Rezoning Transportation Analysis

Petition Number: #2022-096

Revision Log:

Date	Description
11-28-22	First Review (TM)
6-21-23	Second Review (DR)
7-28-23	Third Review (ME)
8-23-23	Fourth Review (ME)
10-26-23	Fifth Review (TM)

REZONING SITE PLAN

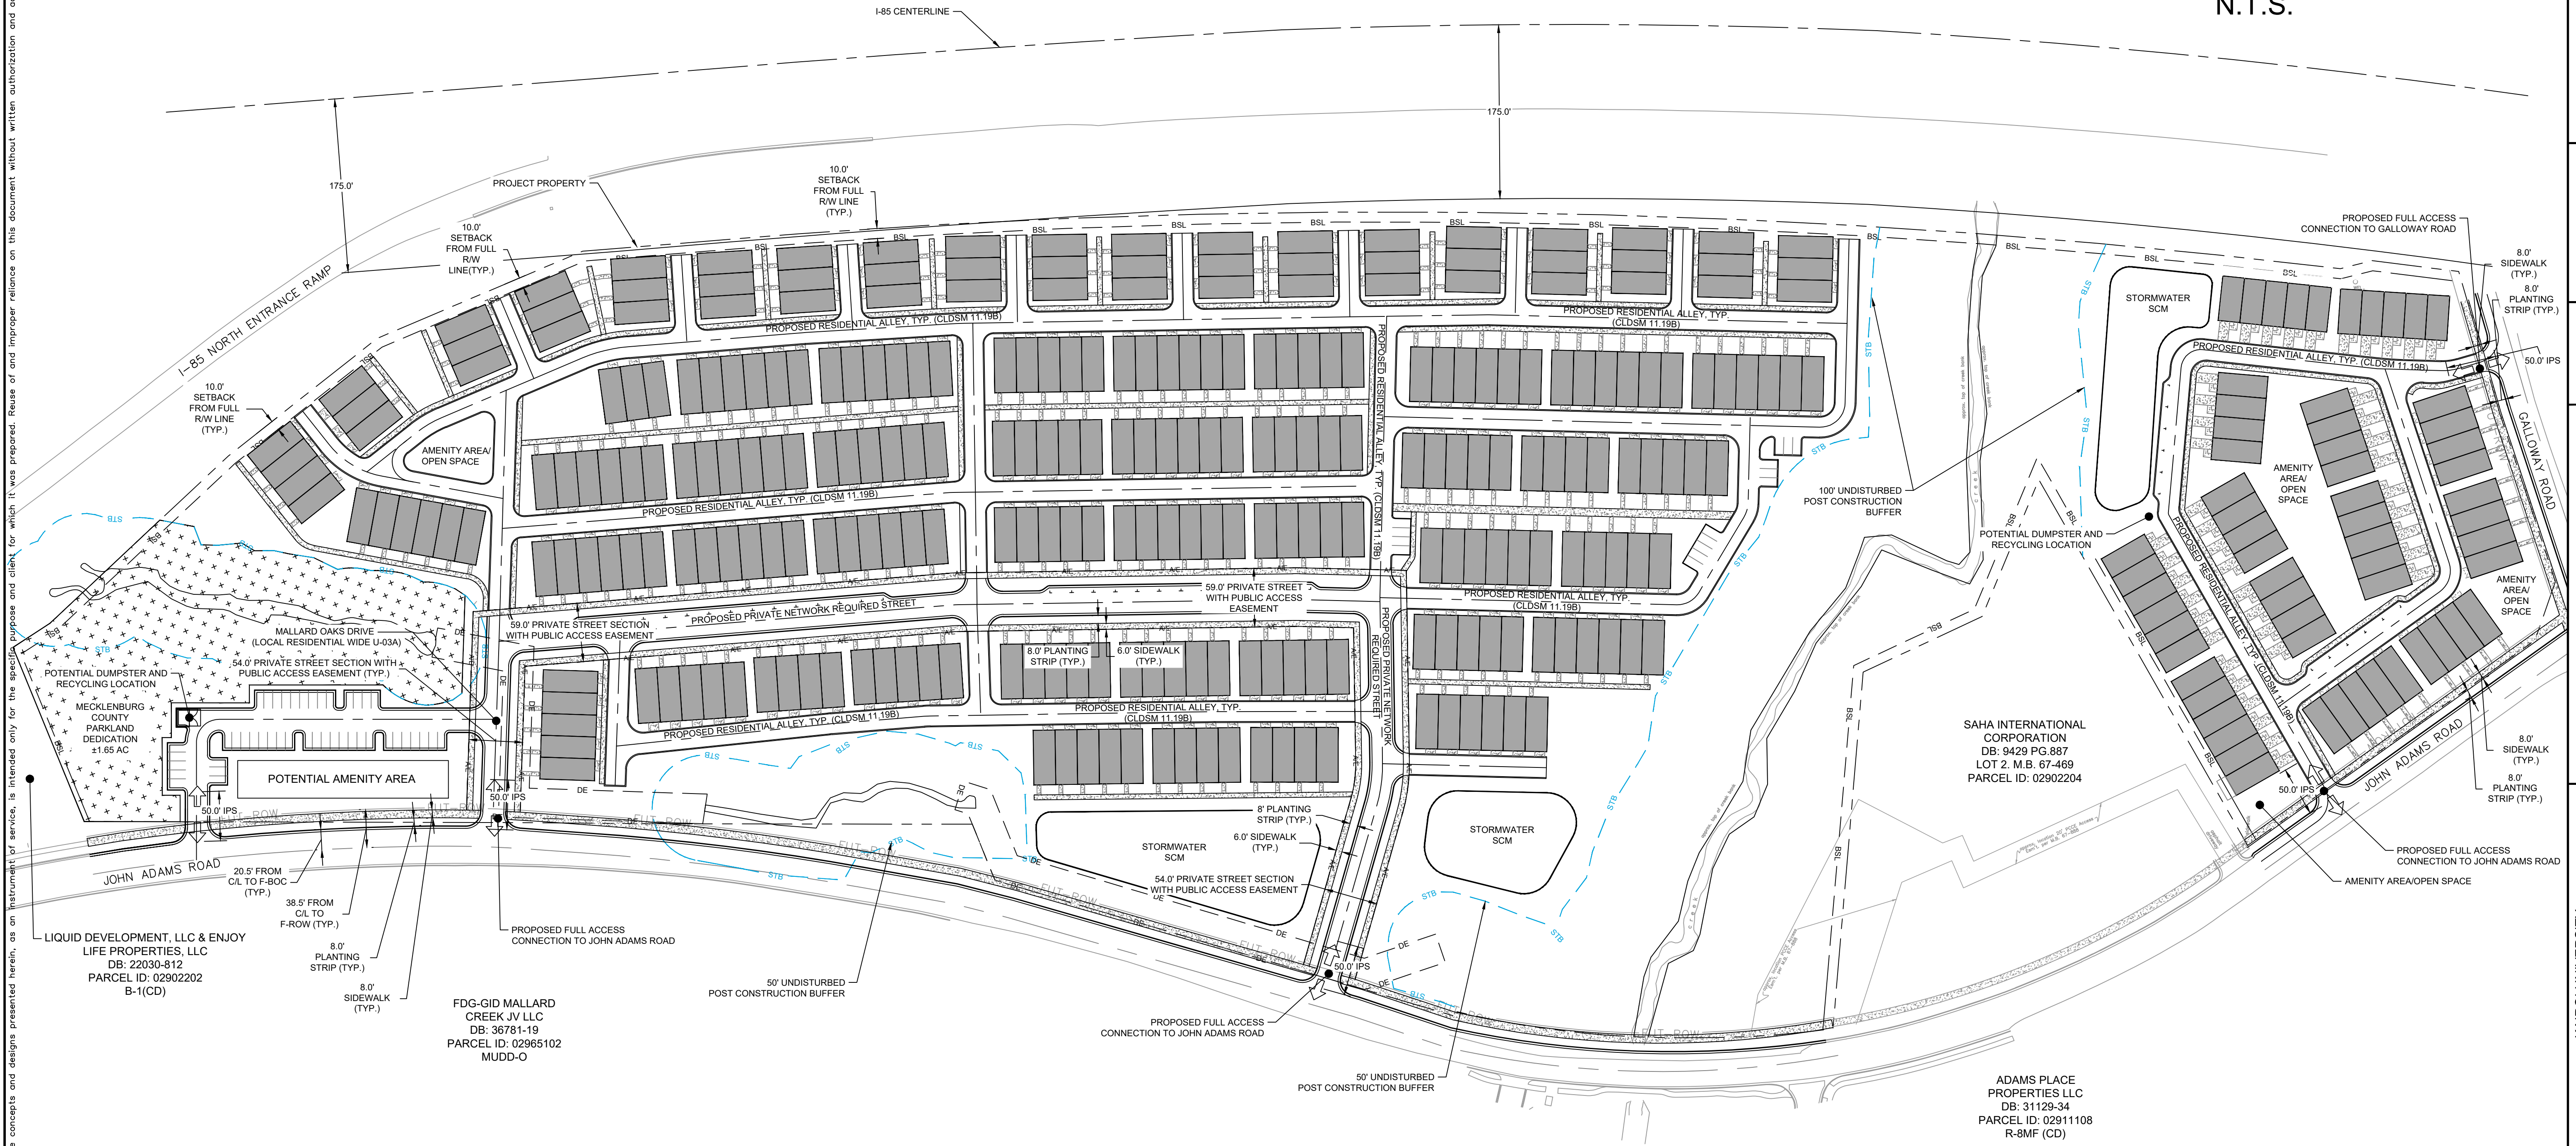
- a. ~~**John Adams Road:** curb and gutter is located 20.5 feet from the roadway centerline to the future back of curb.~~

~~Label and dimension the curb and gutter from the centerline for each road on the site plan.~~

~~Clarifying comment 6.21.2023: Label and dimension 8-foot planting strip and 8-foot sidewalk on John Adams Road.~~

~~Clarifying comment 6.21.2023: Label and dimension 8-foot planting strip and 8-foot sidewalk on all internal public streets.~~

8. ~~Site plan and conditional note(s) revisions are needed to commit to dedicating right-of-way along with a slope easement along Galloway Road to allow for a future bridge over I-85 to be constructed. Site plan shall label and dimension each from the roadway centerline.~~

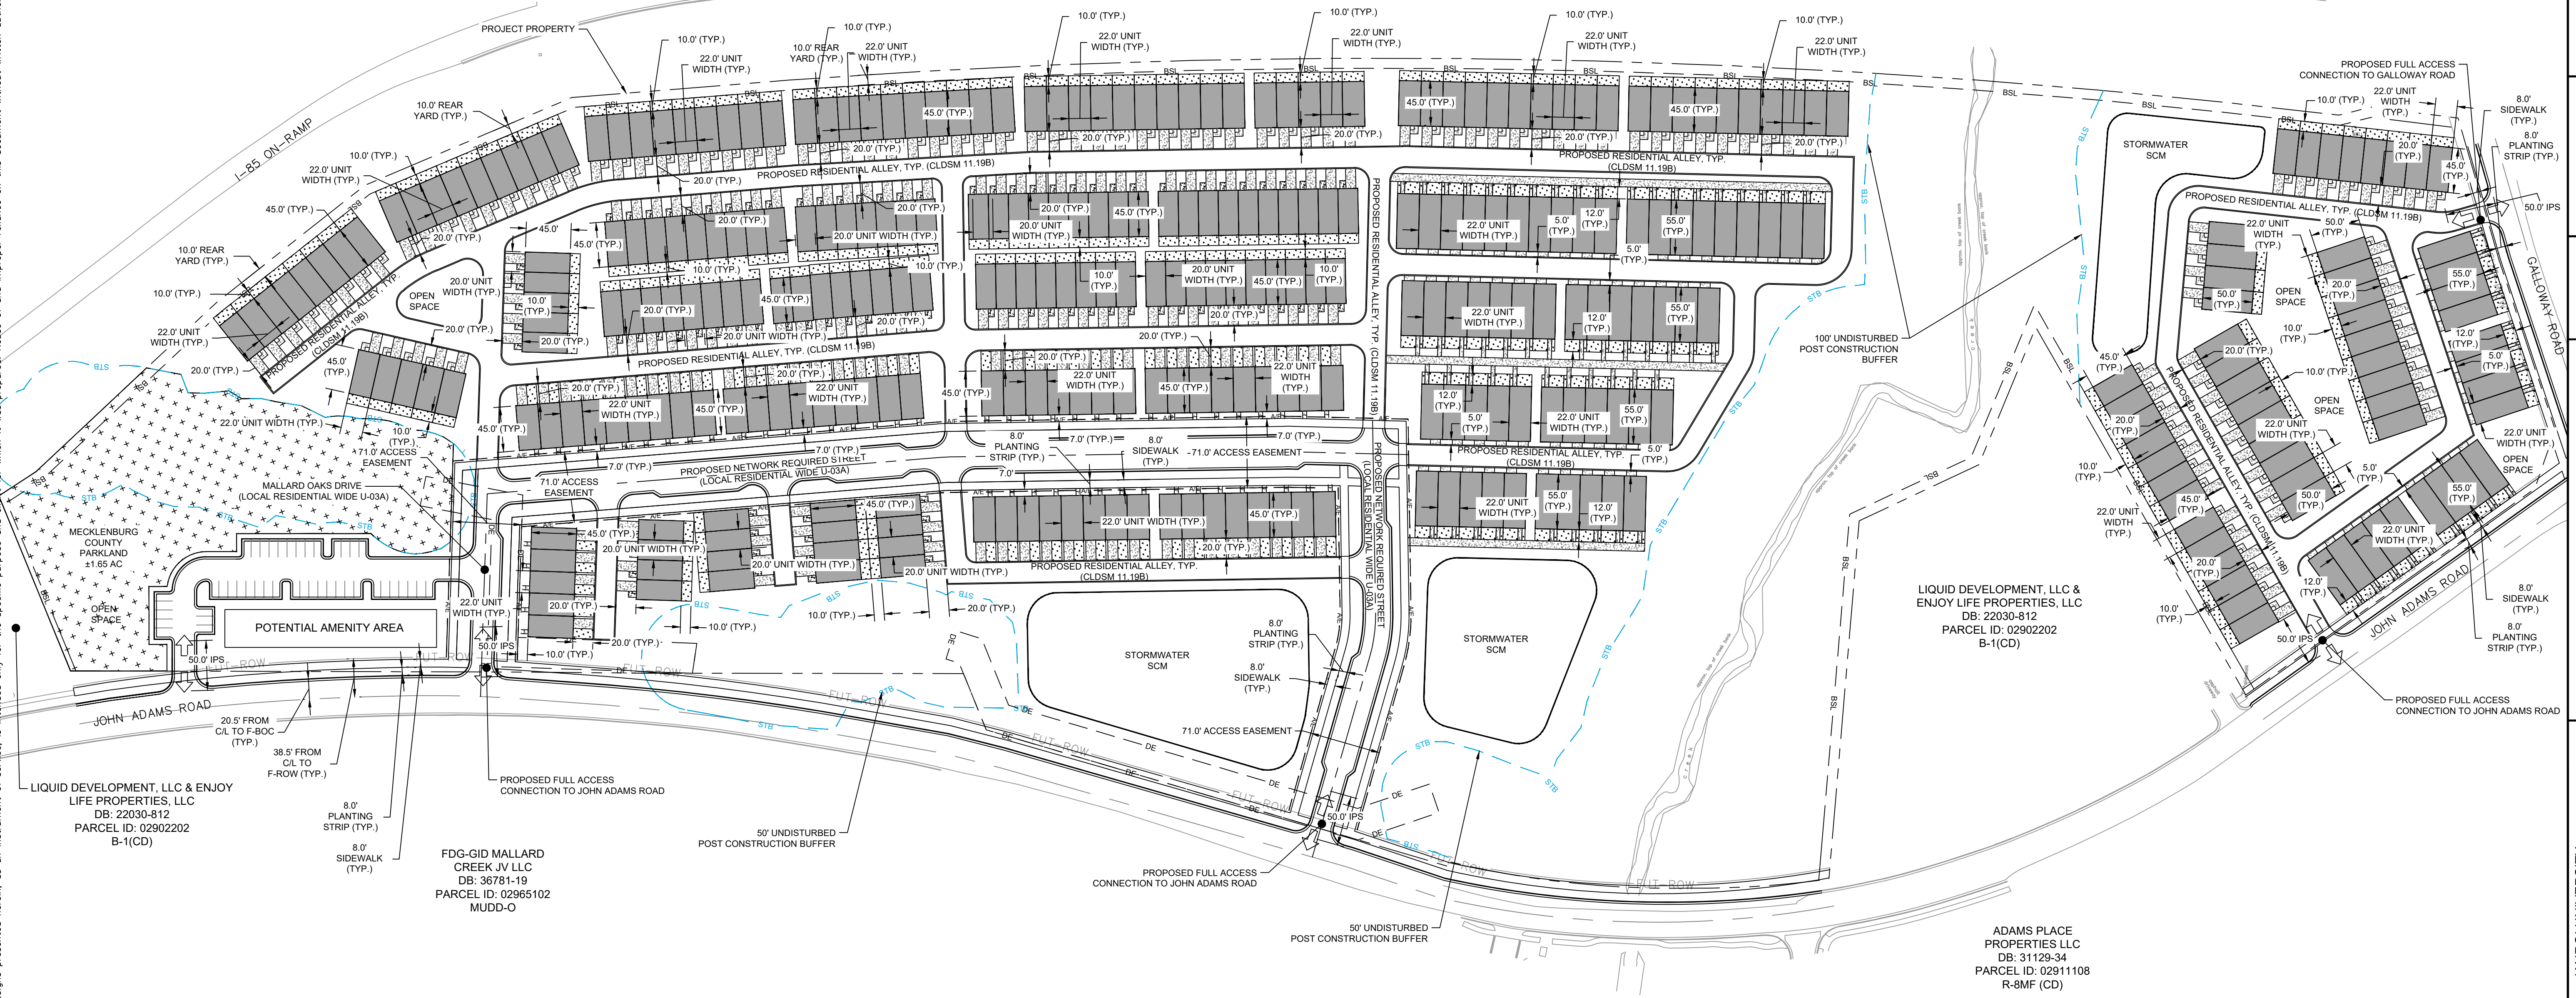
11. **New Comment 6.21.2023:** Label and dimension internal channelization (internal protected stem) and ensure that each driveway provides a minimum 50 feet. No parking shall be allowed within the minimum 50 feet of internal channelization.
